Project # 1007367

Project Name: LANDS OF JOEL P. TAYLOR

Subject: Project #1007367, Site Development Plan for Building Permit, Riverside Church of Christ

**RE: DRB Final Sign-off of EPC Approved Site Development for Building Permit
Legal Description: A-1-B, Lands of Joel P. Taylor
Project # 1007367**

FILE: A301.DWG

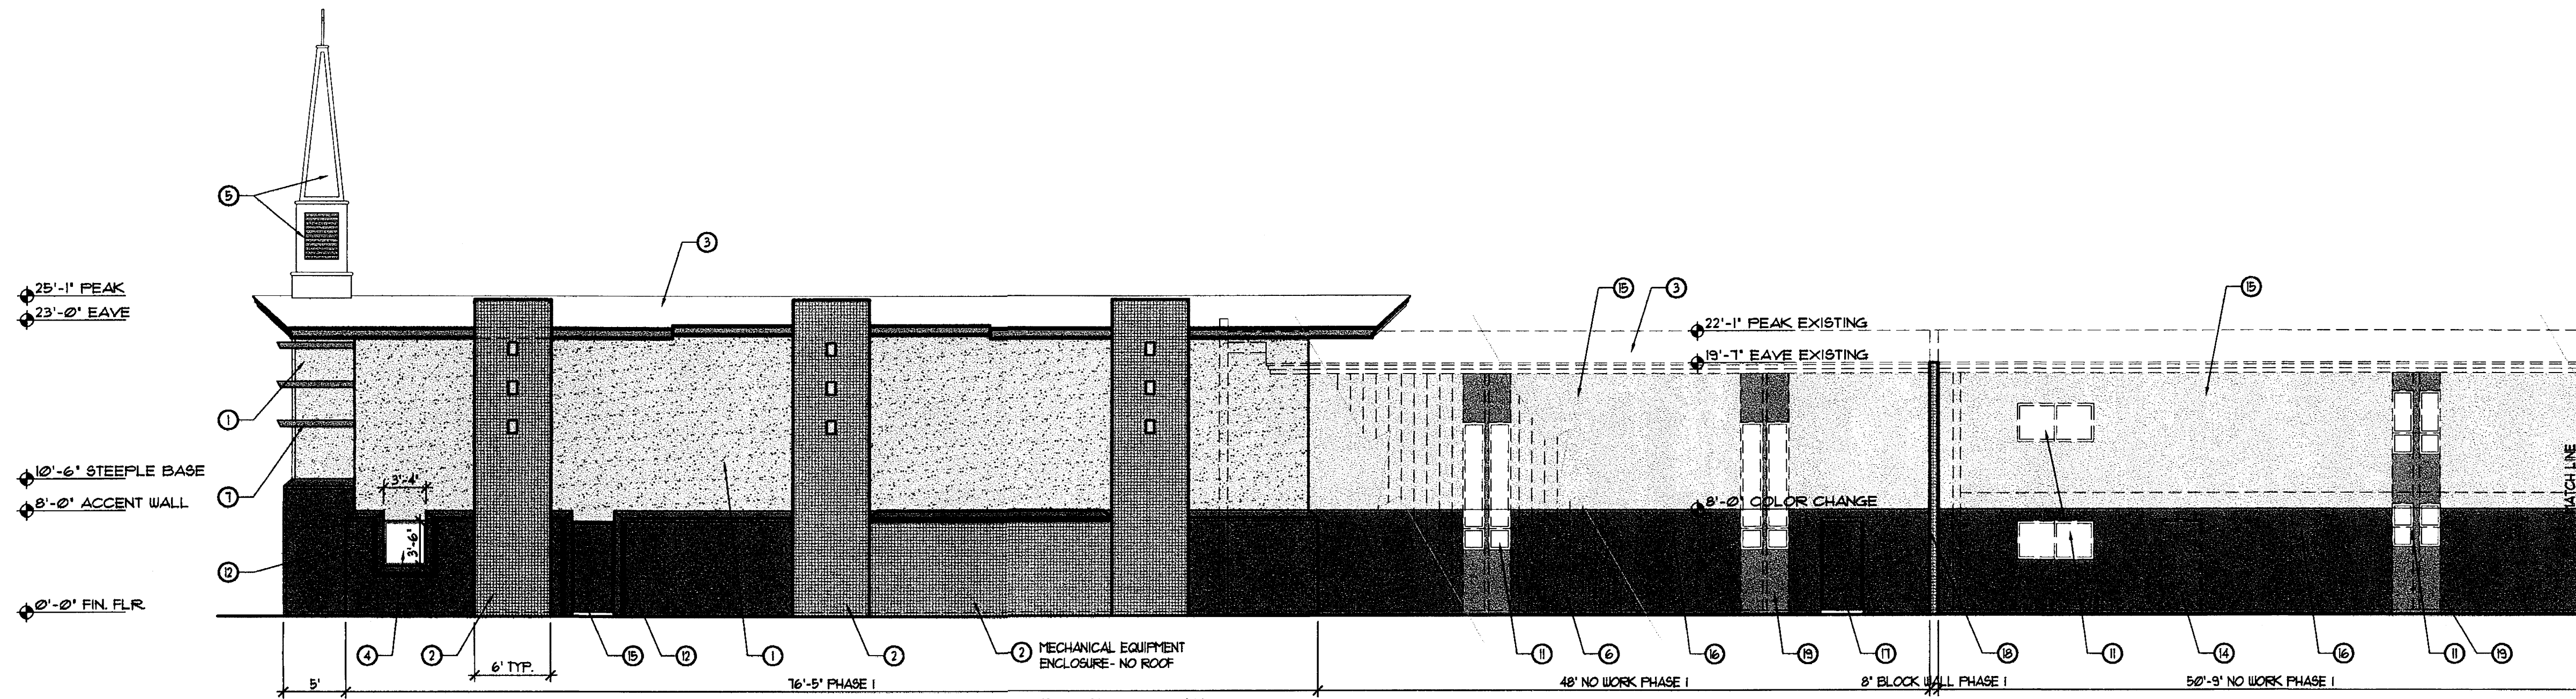
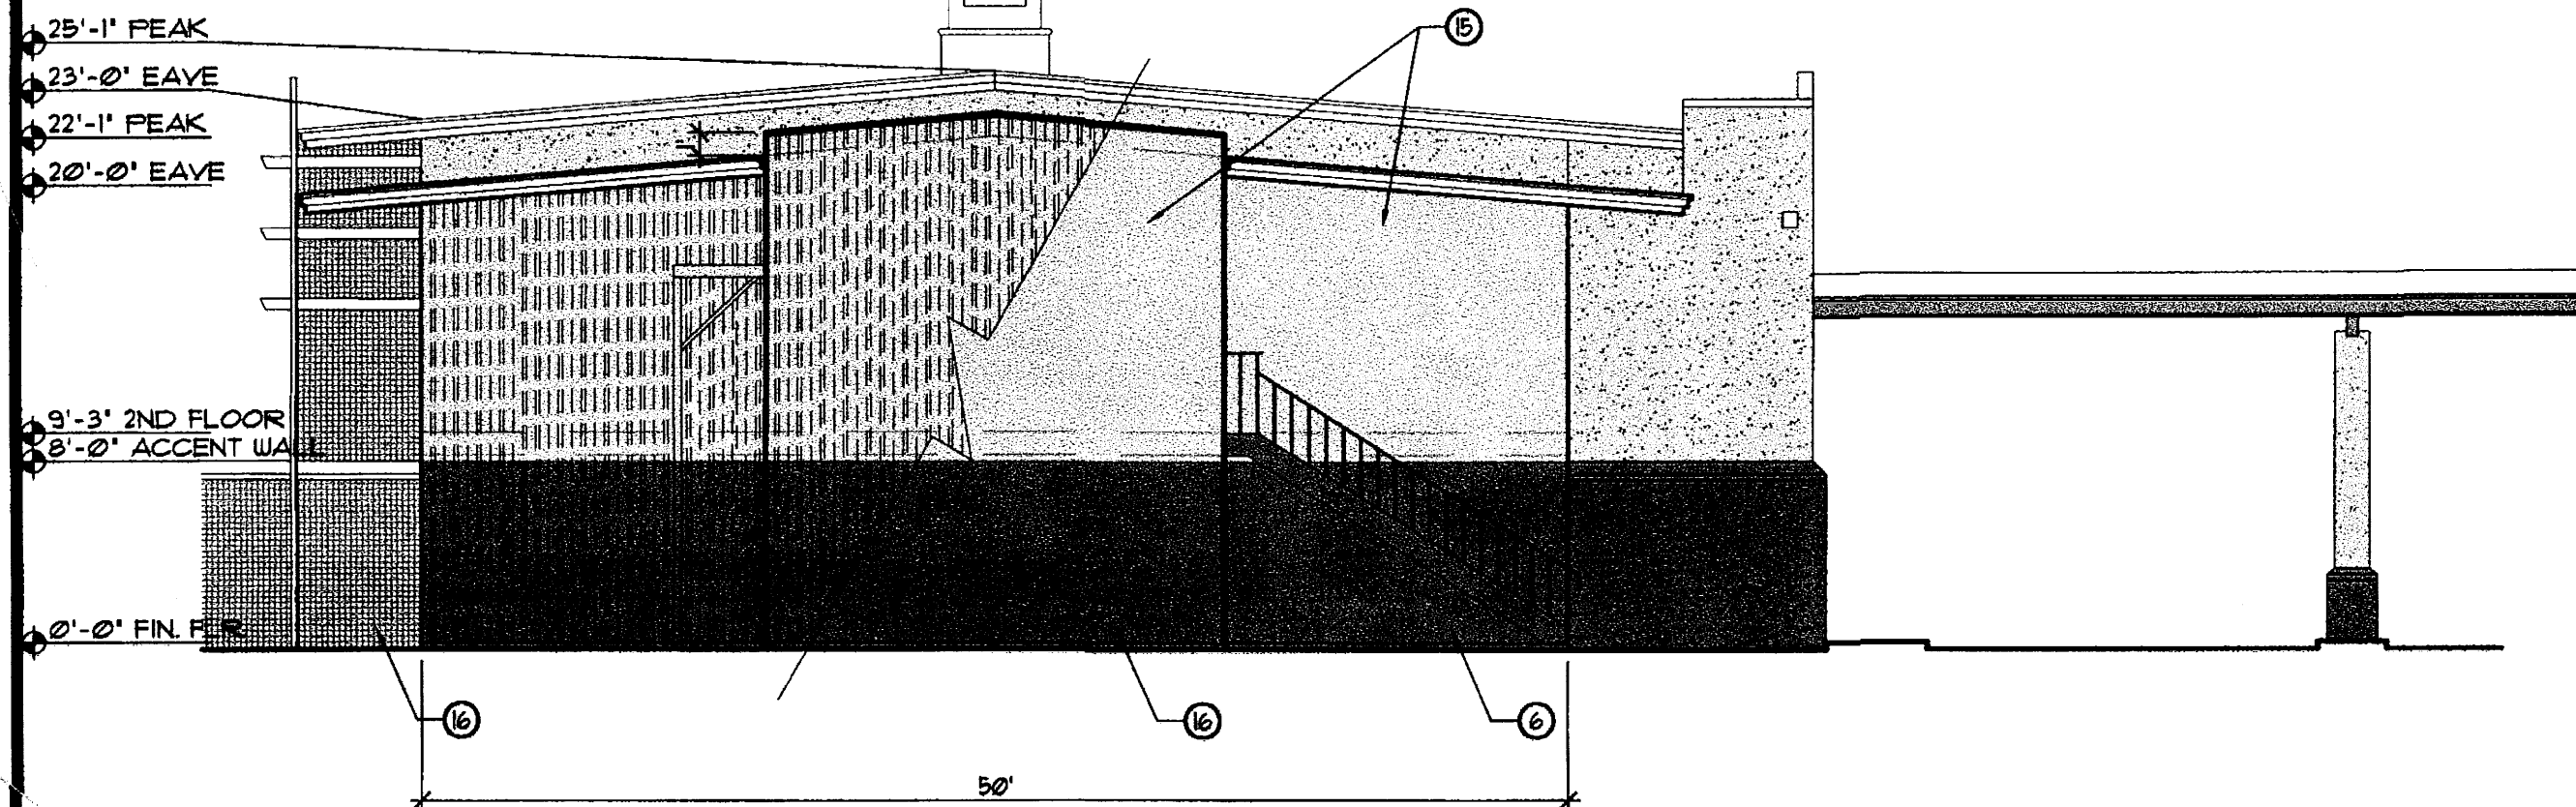
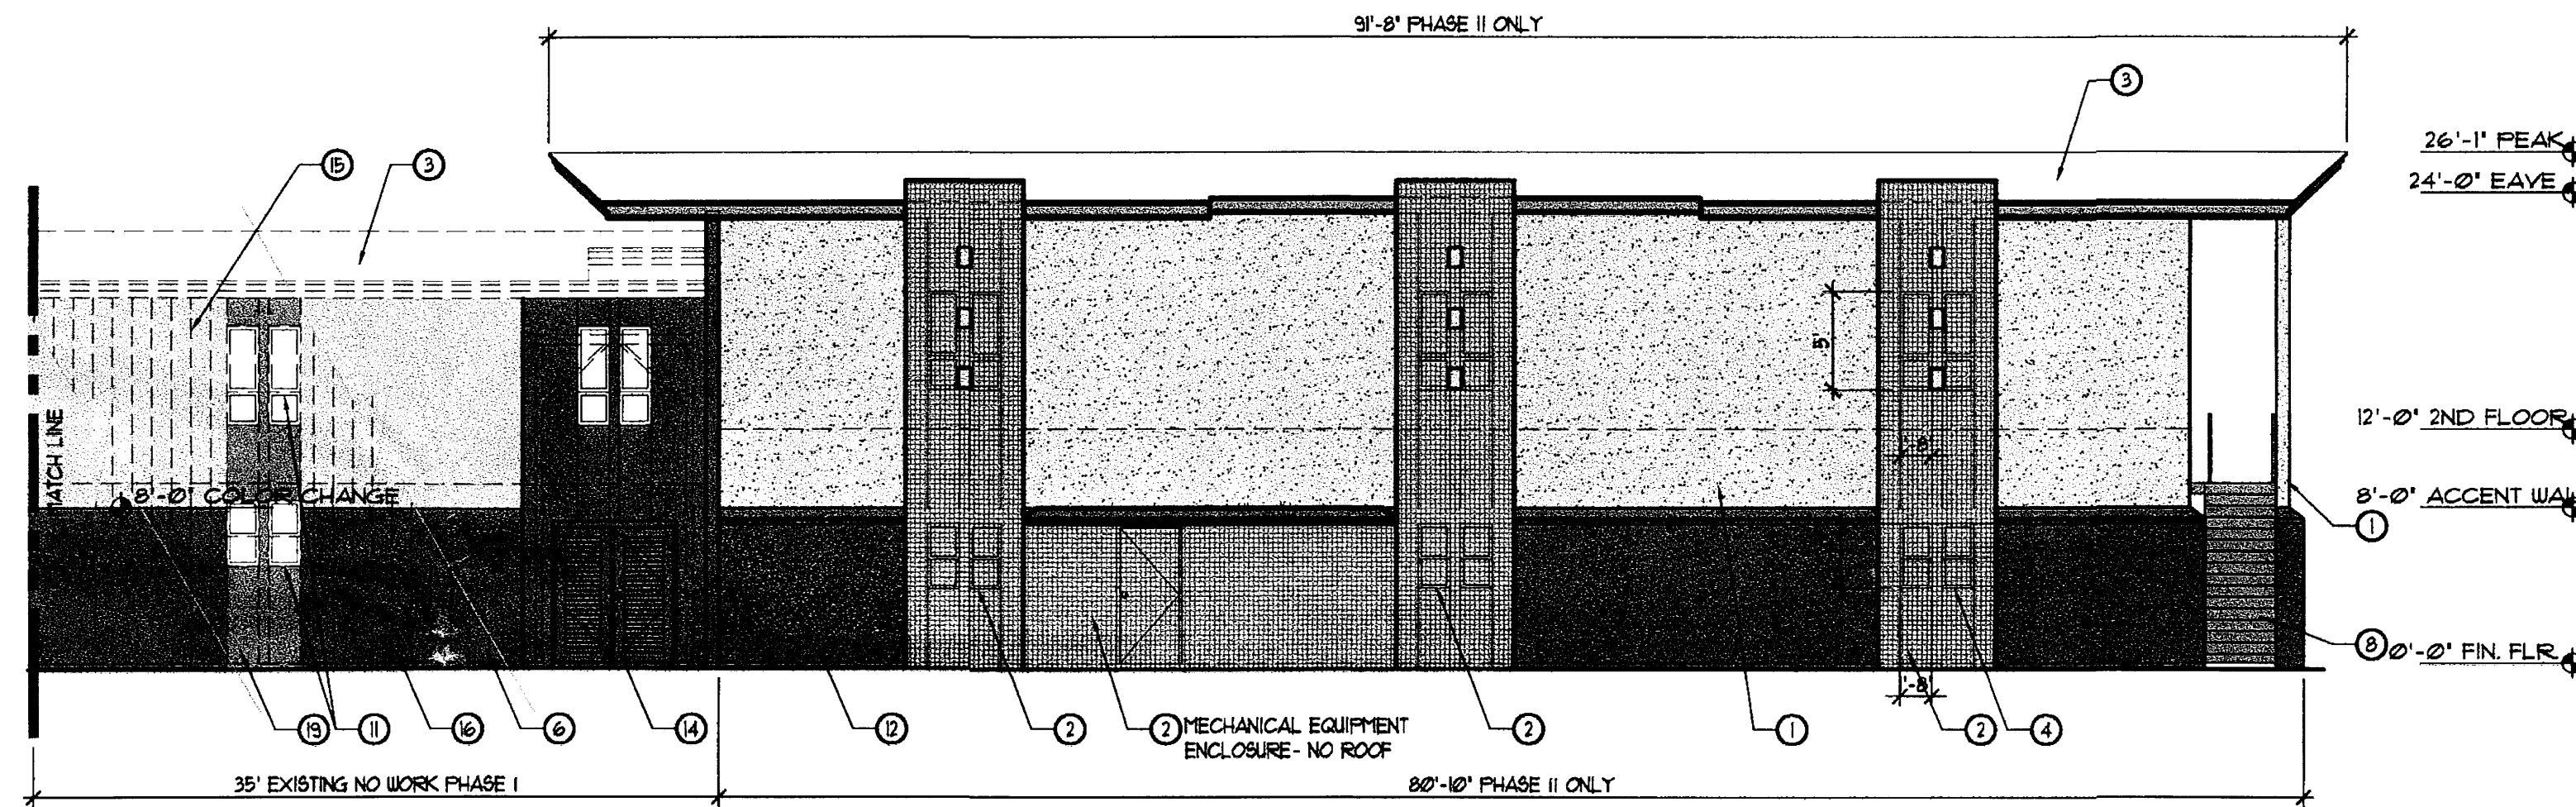
- Add a Keyed Note 17 and a corresponding label to Sheet 301 to indicate that the vertical accent panels will be painted to match the trellises on the additions.
Key note 17 on Sheet A301 was added with the requested information.
- Add a similar note, but numbered 19, to Sheet A302.
Key note 19 was added to Sheet A302 with the requested information.
- The keyed notes for repainting the wall panels shall clarify that the horizontal line is the dividing line between the two colors.
A note indicating the color change at an elevation of 8' was added to the elevations on Sheet A301 and A302.

SHEET NO.  
**A302**  
PROJECT # 08-106 5 OF 5

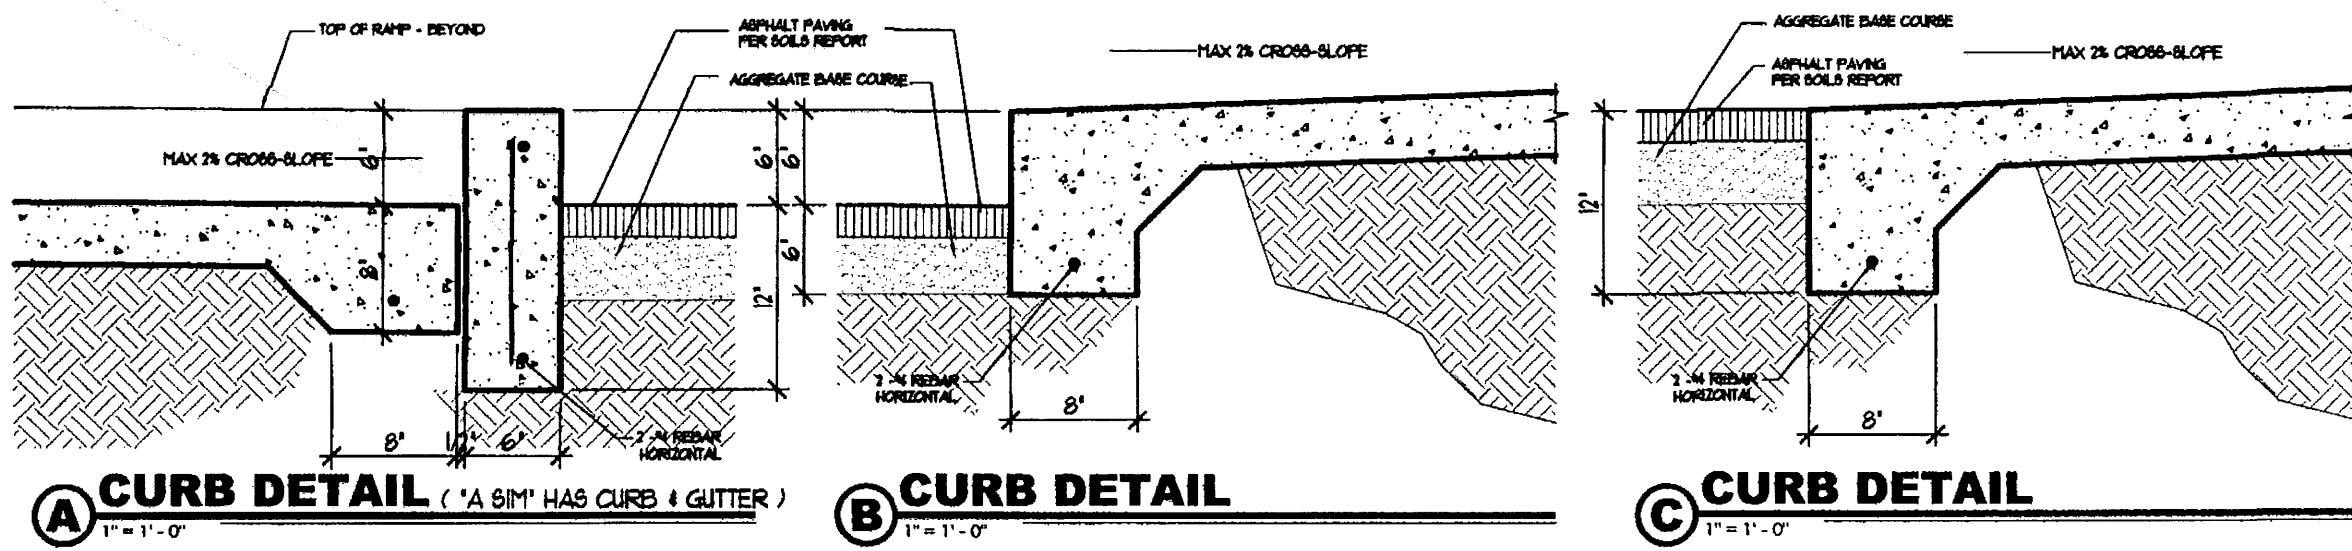
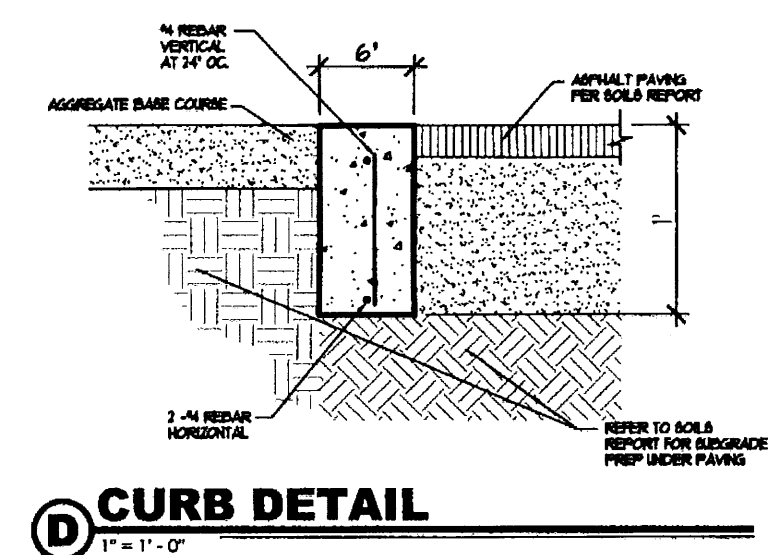
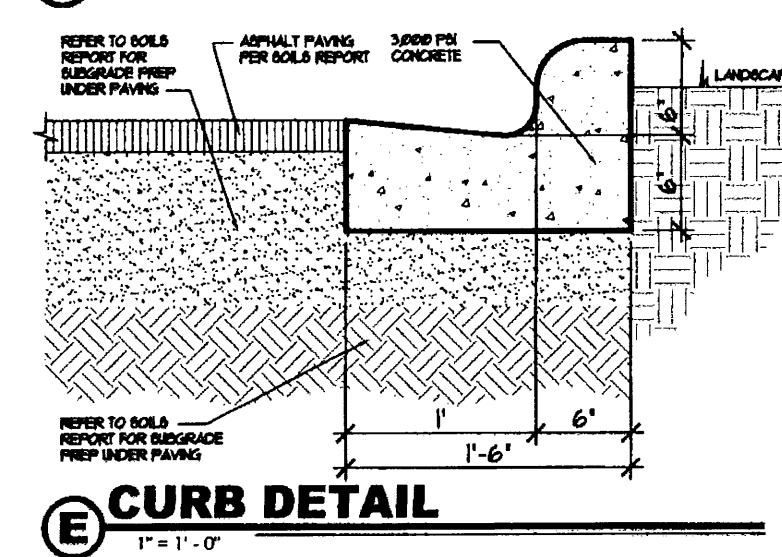
- b. Label and/or clarify curbing requirements between sidewalk adjacent to buildings and main drive aisle.

- d. Remove line type between parking end isles at edge of asphalt, that implies curb and gutter.

Details are shown on Sheet A302 clarifying the different curb types.

A cutoff wall type curb will be built between the edge of asphalt and the aggregate base course to prevent the asphalt from raveling. A detail is shown on Sheet A302.
